**Town of Addison**  
**Summary of Engineering Review Comments**

Date: December 5, 2019  
 Plan Review : Civil Review 2  
 Received: November 13, 2019  
 Plan Date: November 11, 2019  
 Development: Galaxy FBO

Town Project #:19-09D

SHEET NUMBER
LP 1.01

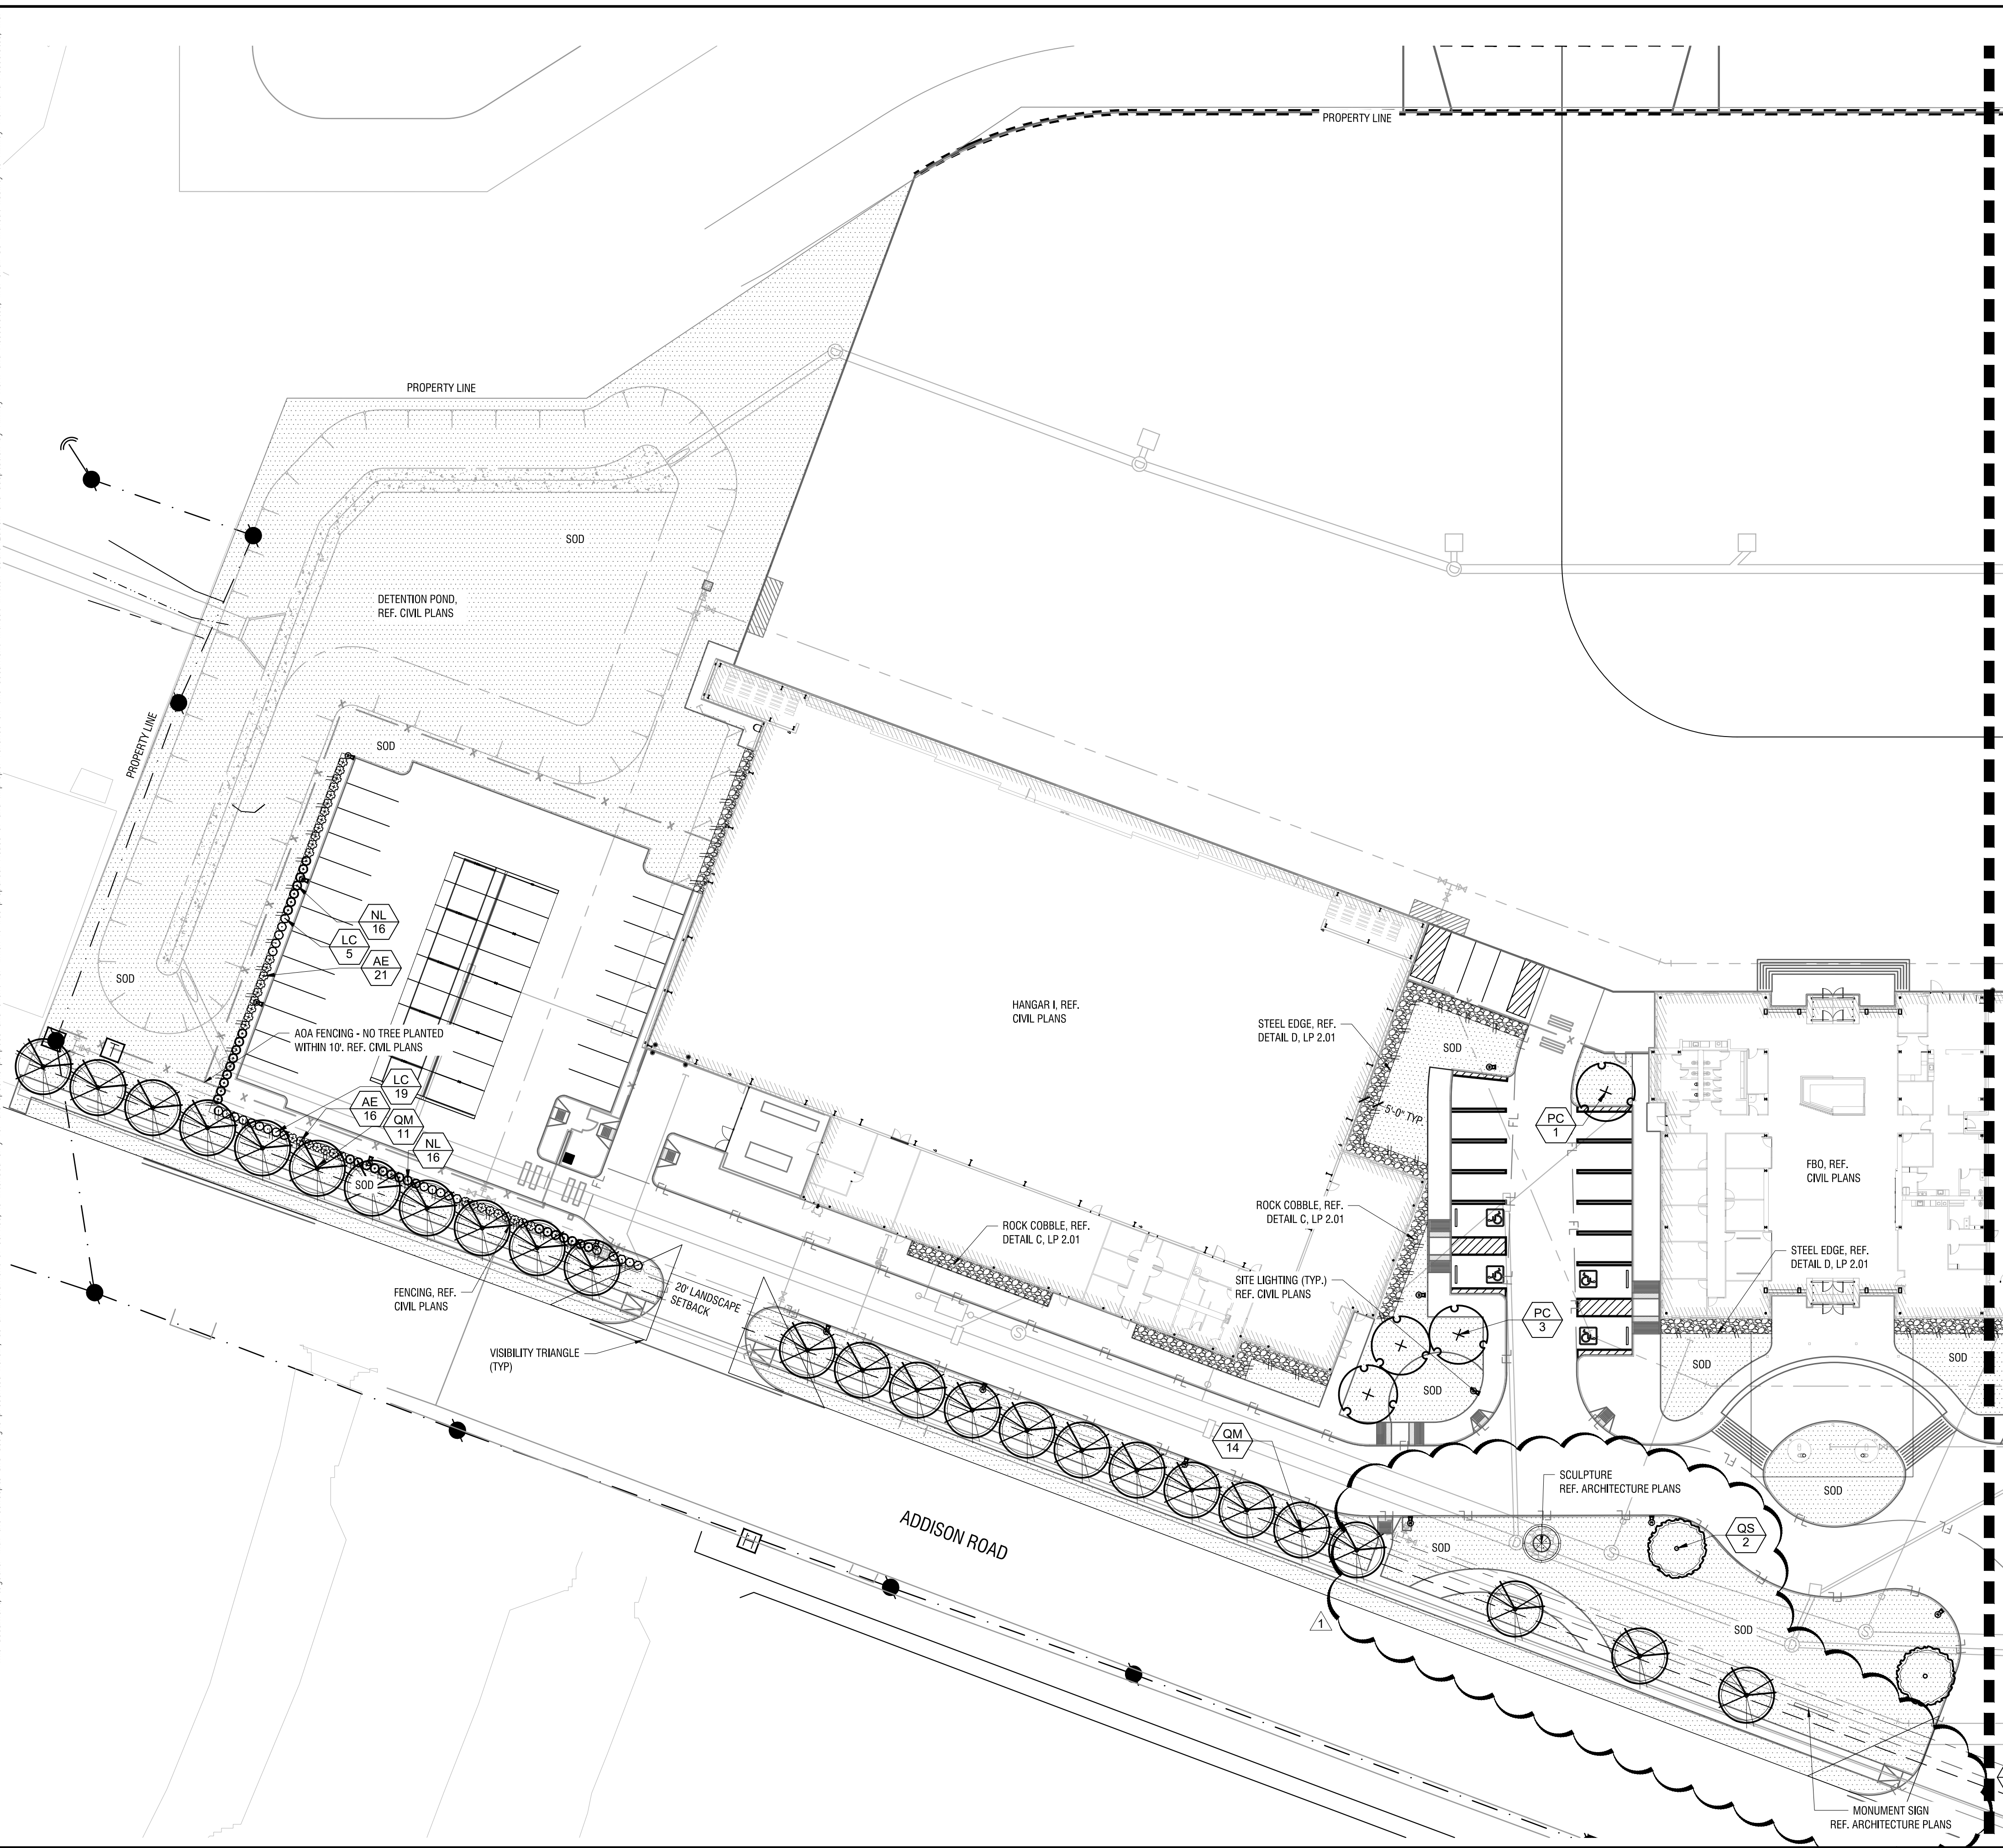
Page No.	Comments	Response (See Note)	Explanation
LP1.01	<b>PREVIOUSLY REQUESTED.</b> Include re-establishment of grass to newly graded/re-graded areas south of site. <i>Call for the landscaping required to re-establish turf/sod/whatever - cannot be left as bare dirt.</i>	AGREE	SOD IS NOW SHOWN TO THE LIMITS OF GRADING. NOTE HAS ALSO BEEN PROVIDED FOR CONTRACTOR TO SEED TO LIMITS OF DISTURBANCE.
LI1.02	Add note that irrigation meter should be field located to avoid conflict with proposed storm drain.	AGREE	NOTE HAS BEEN ADDED.

SHEET NUMBER  
**C13.01**

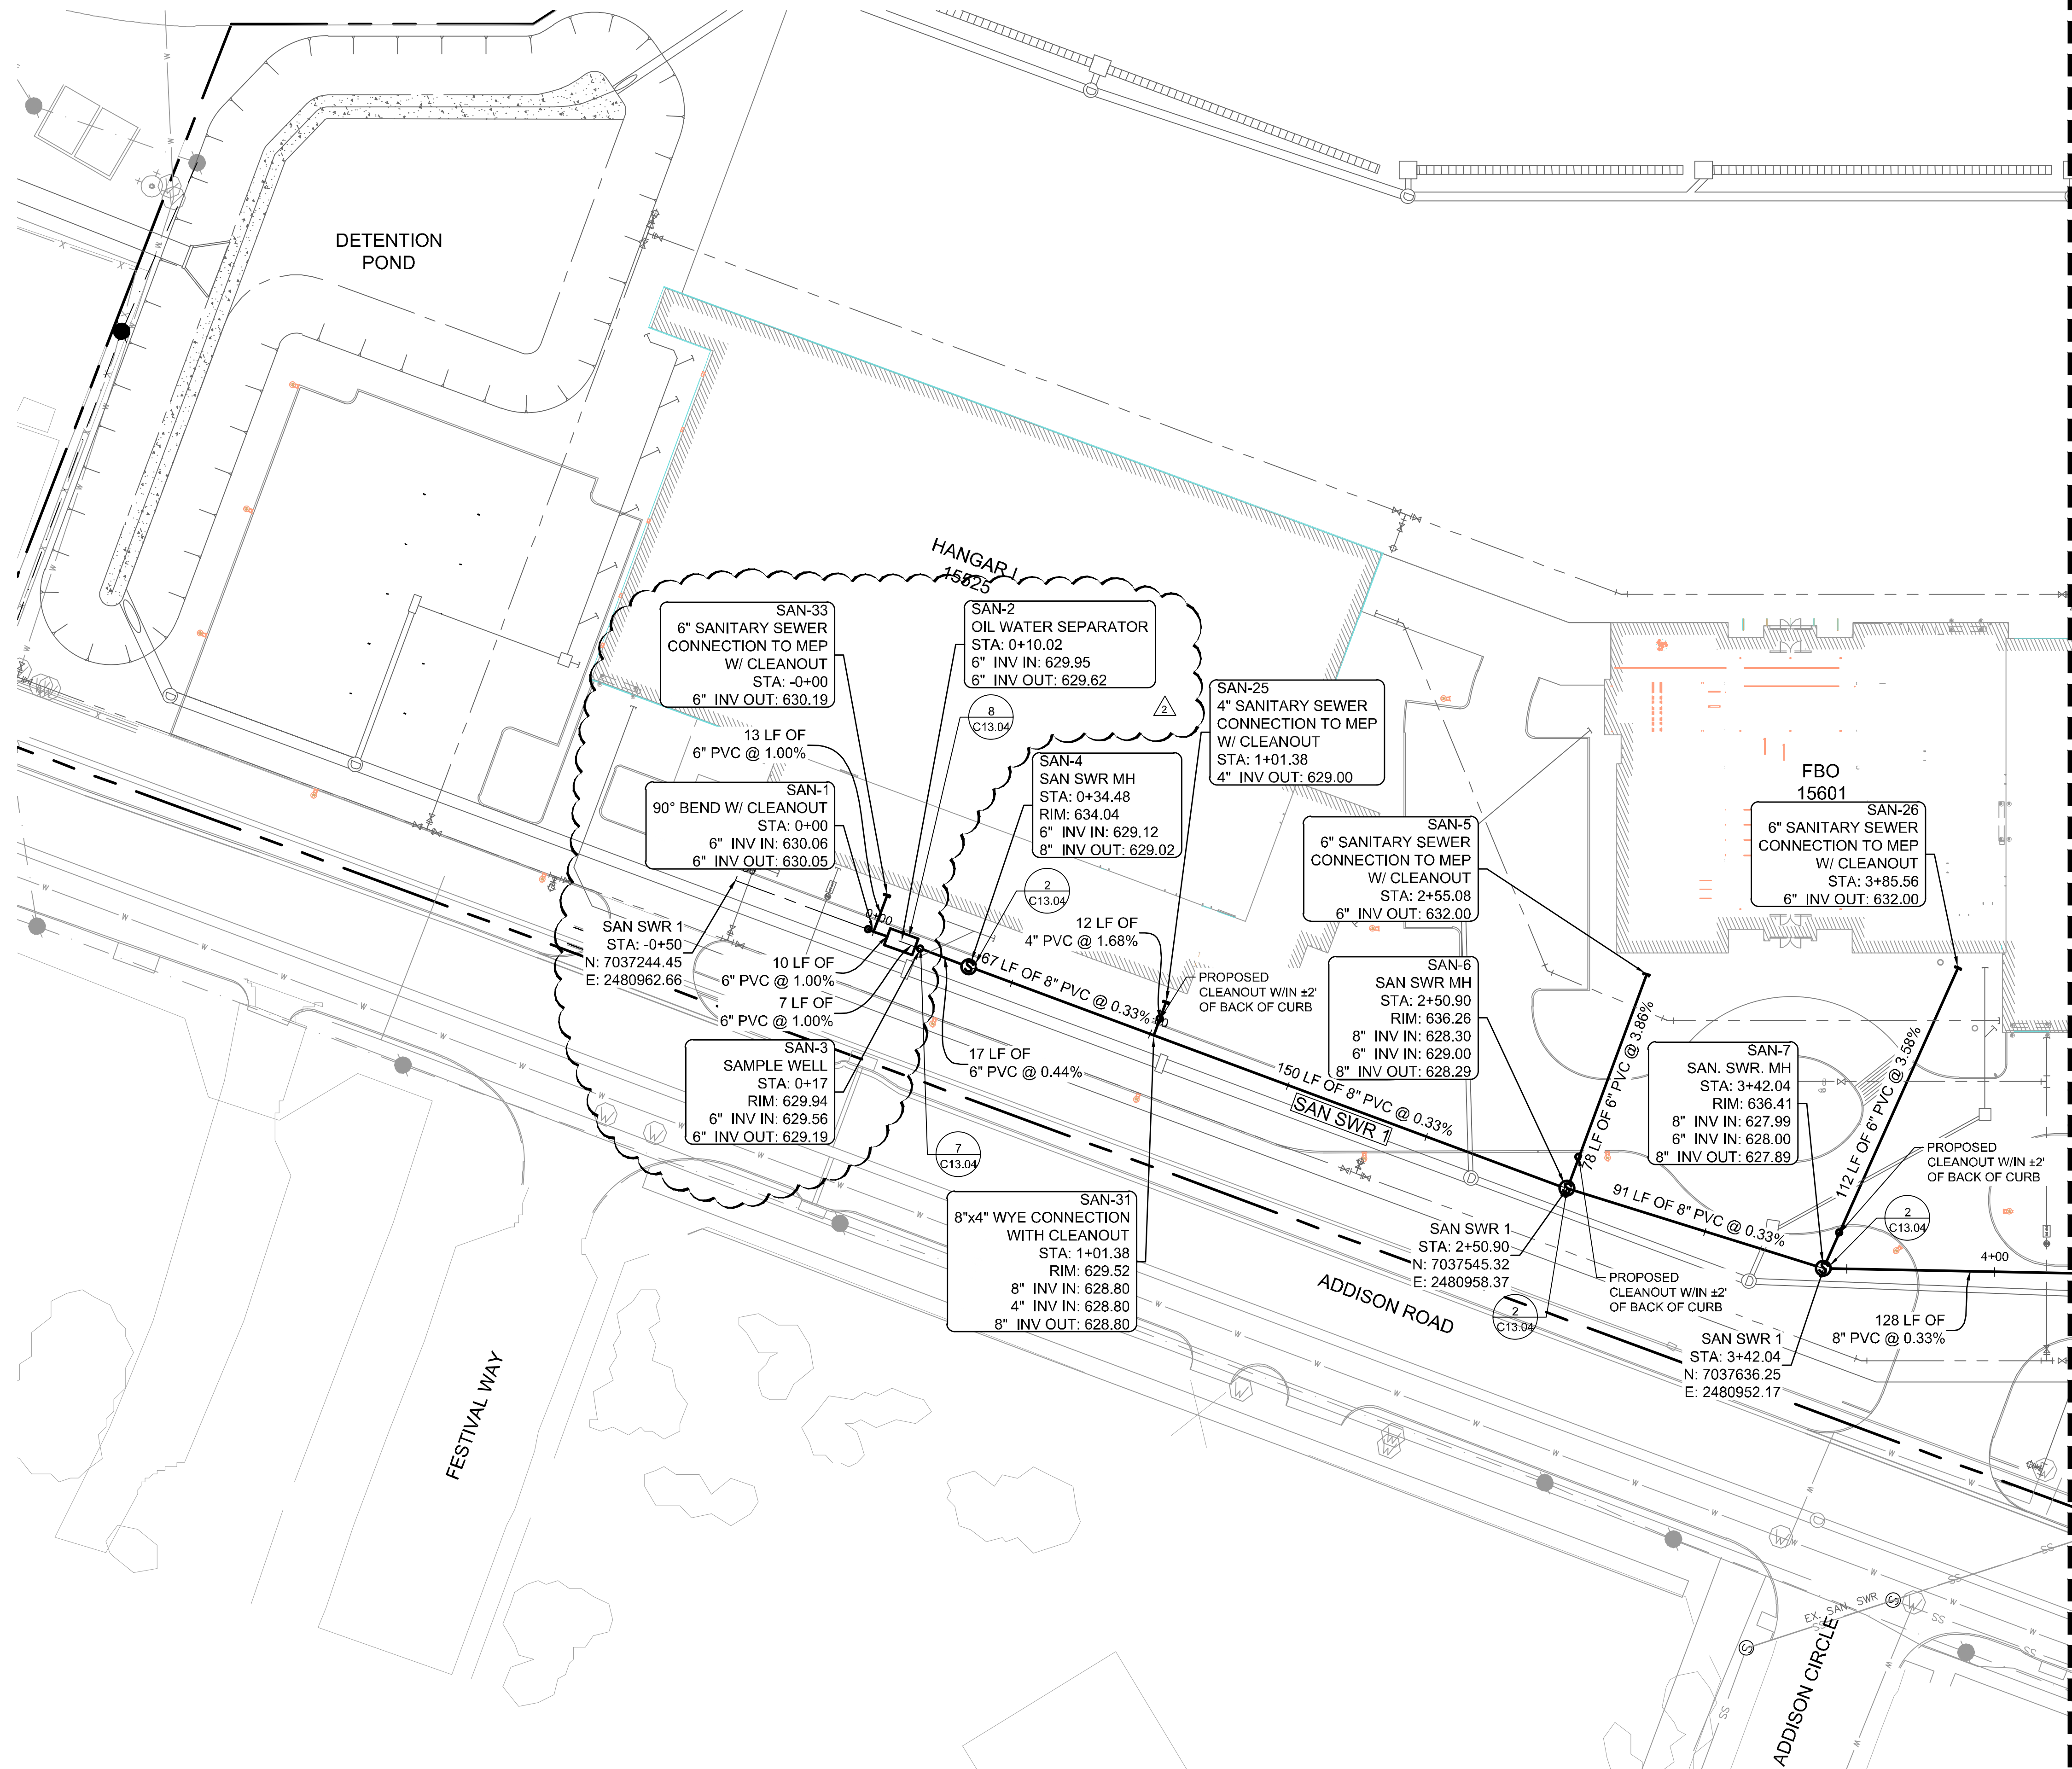
Page No.	Comments	Response (See Note)	Explanation
UTILITY	Add embedment notes from plan view sheets to profile sheets as well.	AGREE	NOTE HAS BEEN ADDED TO SHEET C13.03.
SANITARY	Add civil cleanouts at the back of curb on all services & include TOA standard cleanout detail.	AGREE	THE TOA STANDARD CLEANOUT DETAIL HAS BEEN ADDED ON SHEET C13.05 AND THE CLEANOUTS HAVE BEEN ADDED AT THE BACK OF CURB ON THE SERVICES.
SANITARY	<b>PREVIOUSLY REQUESTED.</b> Legend - why calling for a clamp?	AGREE	CLAMP CALLOUT HAS BEEN REMOVED.
C13.01	Show 90bend on the the sanitary service out of Hangar 1 to indicate it will not cross the water services.	AGREE	A 90° BEND WITH A CLEANOUT HAS BEEN SHOWN TO INDICATE THAT THE SANITARY SEWER SERVICE DOES NOT CROSS THE WATER SERVICE LINES.
C13.01	Why are you calling for DI on the 4"?	AGREE	ALL SANITARY SERVICE LINES HAVE BEEN CHANGED TO PVC.
C13.01	SAN-25 doesn't have a station in the callout	AGREE	SAN-25 NOW HAS A STATION IN THE CALLOUT.
